6 August 2025

Development Referral No. DN25/0020

Proposal: Notification of Modification Application Kurnell Refinery Conversion Project SSD 5544 MOD 7

Property: 160-166 Captain Cook Drive, Kurnell

Figure 2-1 The proposed modification

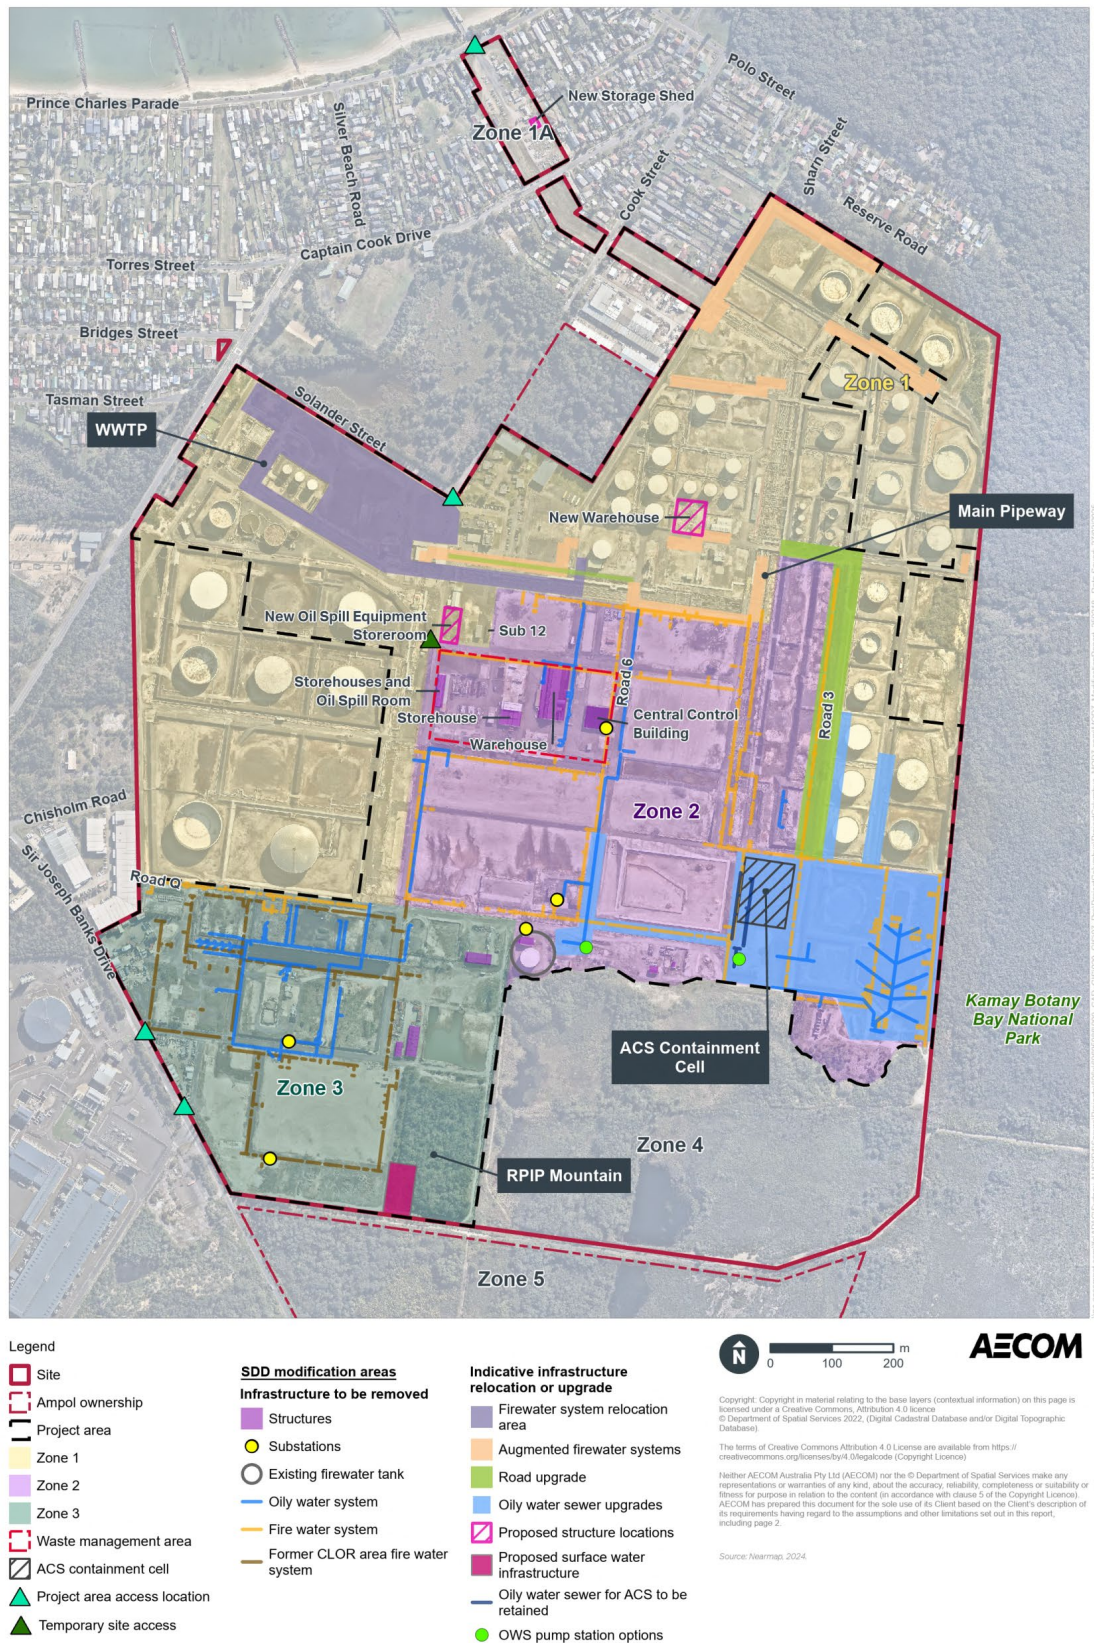
- Additionally, throughout the report, it is detailed that the location of new buildings, works and the like have not been finalised. This is not supported. The location of all site improvements, buildings, levels, and the like must be confirmed prior to any determination of this application.

- On Page 129, the report refers to indicate locations of infrastructure, buildings and the like. The application must confirm the location of all buildings, infrastructure, services, works to be demolished and/or constructed.

**FIGURE F3:
FIRE WATER SYSTEM AND
OILY WATER SEWER**

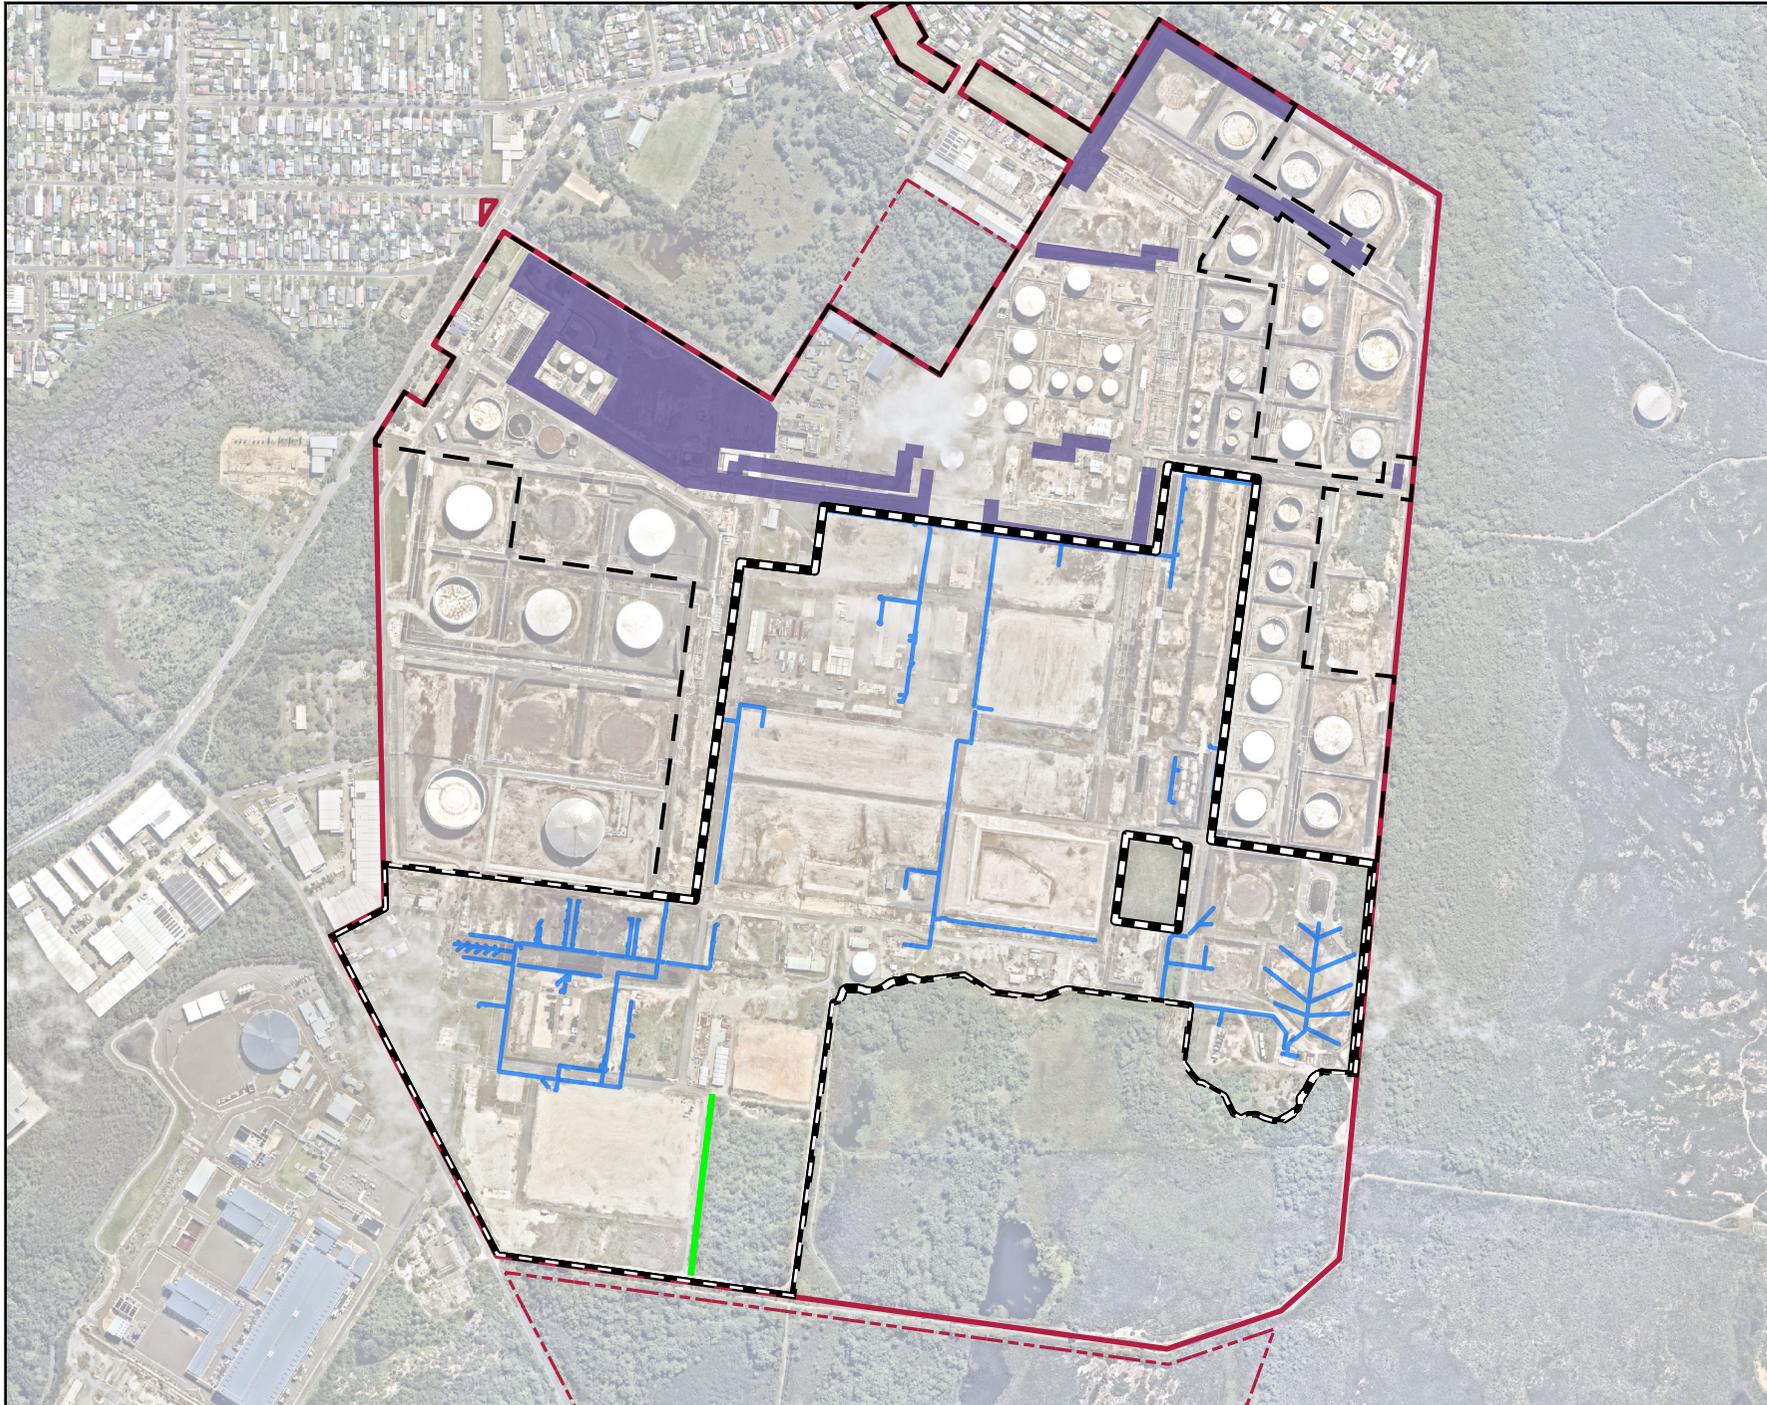
- Questions are raised regarding the capacity of the Oily Water System (OWS) and whether the system has capacity to cater for the future developments likely to be undertaken within Zones 2 and 3. Further information is needed.

- Page 28 details that the location of the new OWS permanent pump will be selected during the detailed design phase. This is not supported. Detailed plans must be provided to enable a comprehensive assessment of potential impacts. The plans must not be limited to the actual pump, but all ancillary infrastructure required to be installed (i.e. pipelines, ancillary pumps, etc.).

- Page 28 details that the 'if' Firewater Systems (FWS) is removed from Zone 2, it would be relocated to Zone 1 and there are two options for the new location. This is not supported. The location of the FWS must be known to enable a comprehensive assessment of impacts, particularly as the tank would be 12m in height and 22m wide. It is acknowledged that there several tall petroleum tanks located onsite, but the location must be known in order to determine the potential visual, acoustic and other impacts particularly from the adjoining and nearby sensitive receptors.
